Comments for Planning Application 23/01165/FUL

Application Number: 23/01165/FUL

Address: Pilot House Embankment Road Bembridge Isle Of Wight PO35 5NR

Proposal: Demolition of dwelling & commercial building; proposed replacement dwelling (C3 (a) Dwellinghouses) & 19no. industrial units (B2 General industrial & B8 (storage or Distribution)

BLOCK PLAN

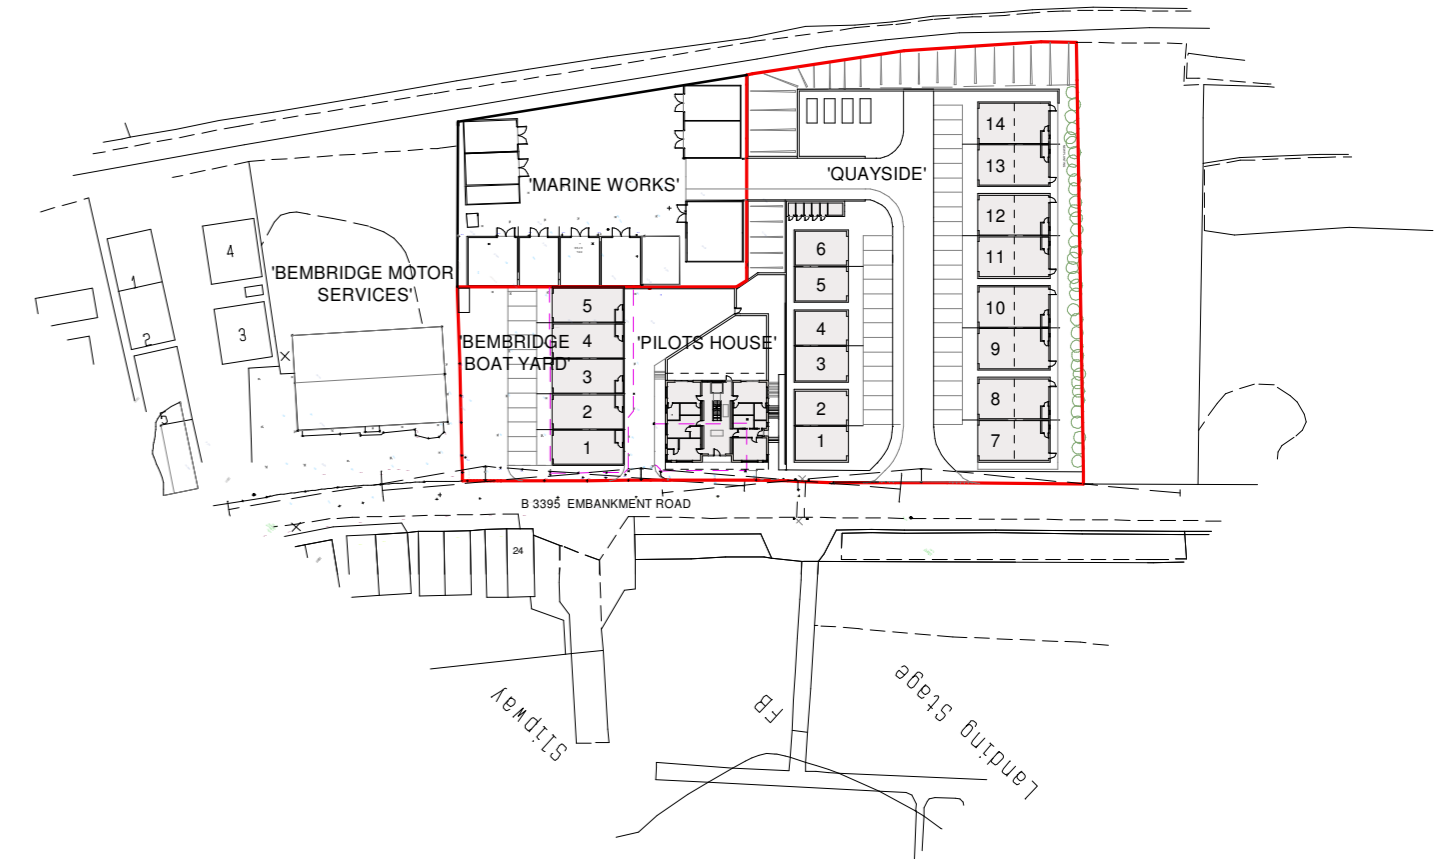
Comment: The Isle of Wight Area of the Ramblers notes that this application includes reference on the site drawings to a "Footpath" which is marked between the properties and the marsh edge. It is important that the line of this footpath within the applicants control is confirmed as dedicated in order to allow the future formation of a continuous route through the area.
